From: [REDACTED]
To: [Great Yarmouth Third River Crossing](#)
Subject: RYA's Submissions
Date: 08 October 2019 00:49:08
Attachments: [2-SoCG-table.pdf](#)
[3-RYA-PrelimHearing.pdf](#)
[4-RYA's-OpenForumStatement.pdf](#)
[5-GYTRC_7.5-RYA-SoCG-DRAFT3-07-Oct-2019.docx](#)

RYA's Preliminary Meeting Statement (*intended*) – **[Gt.Yarmouth Third River Crossing]**

Great Yarmouth Third River Crossing Application for Development Consent Order

Document 7.5(??): Royal Yachting Association (RYA)

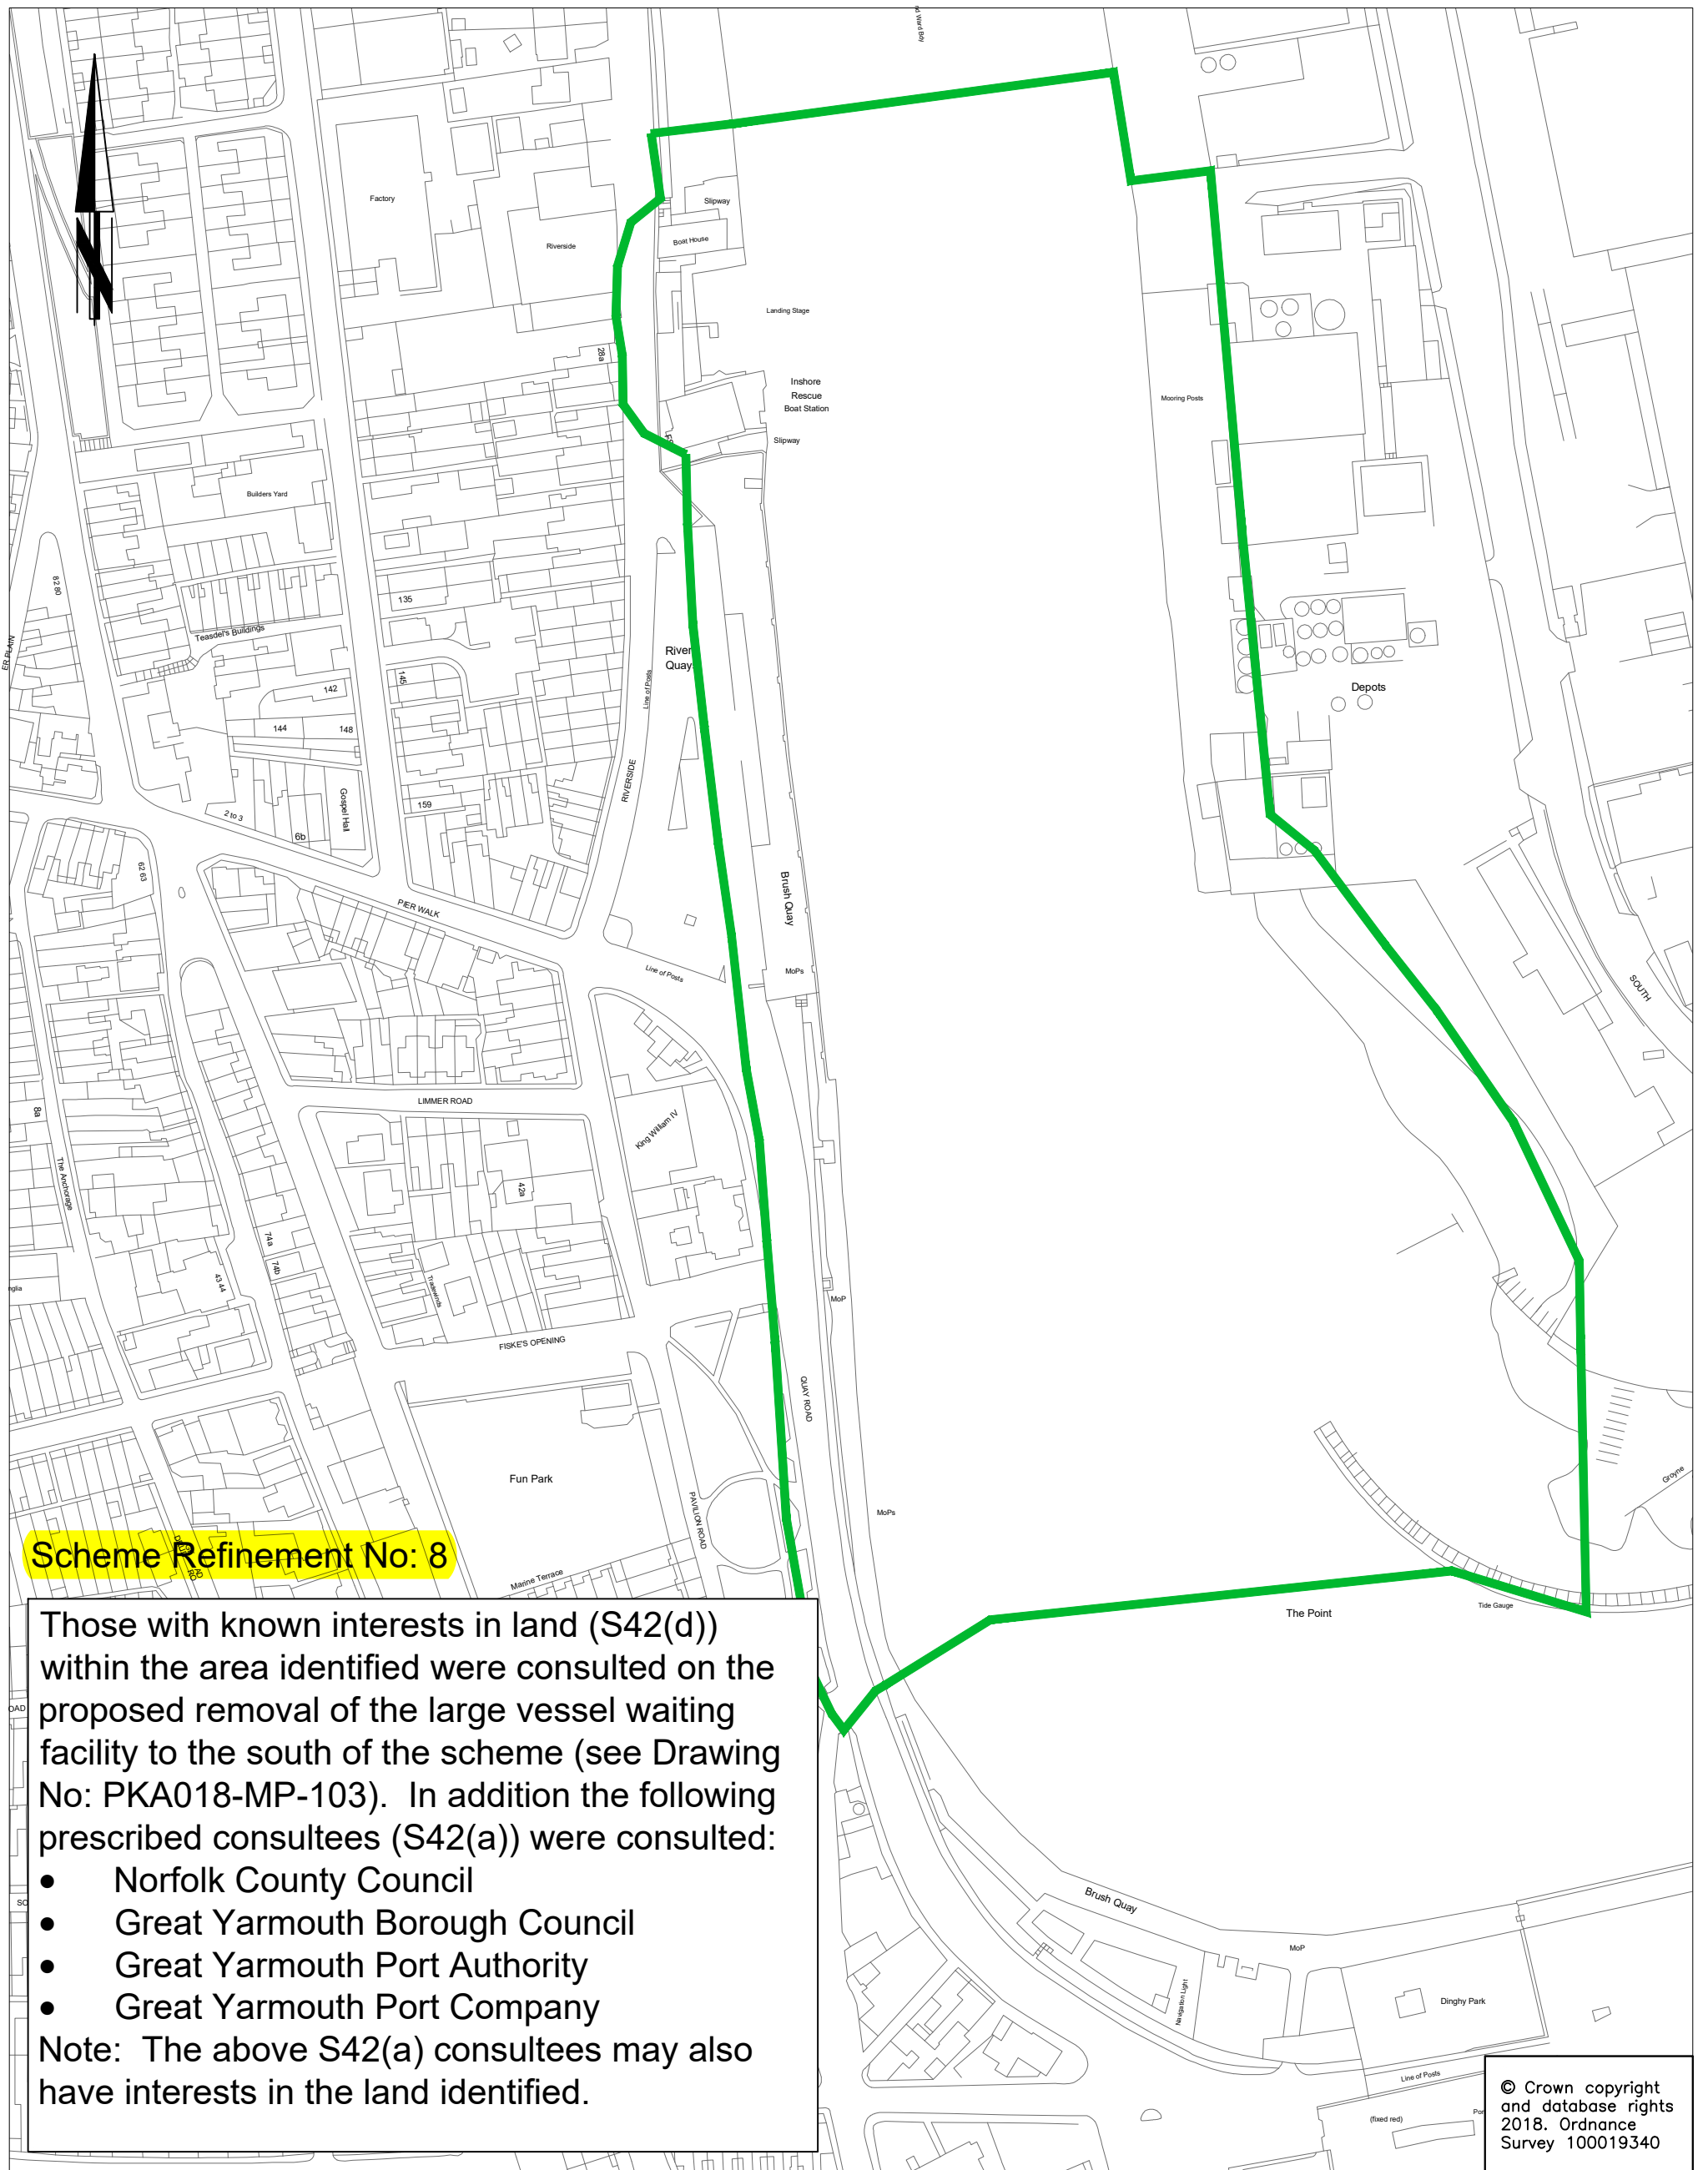
Applicant has shown the intended new Vessel Waiting Facilities at two quadrants of the new bridge;

it has been indicated that these are in effect the "waiting pontoons".

RYA has stated that these should Not be potentially inappropriate large-vessel fenderings.

Waiting pontoons for small-boats are welcomed;
however there has been muddying between

"Waiting Pontoons for small-boats"

and **"Waiting Berths for large-ships"**

To expect small boats to moor and wait adjacent to the new bridge, on the outside of a bend at times when large vessel movements might be expected is at very least foolhardy, if not wholly dangerous.

Any boat placed alongside at these two positions partially covers the impact-protection-zone along the piers and places the boat at risk of being crushed should the ship veer off-course.

Waiting Pontoons for small-boats must be placed ...

- (i) safely away from the risk-zone of the bridge passage channel and**
- (ii) out-of-line of an ambient steering-direction.**
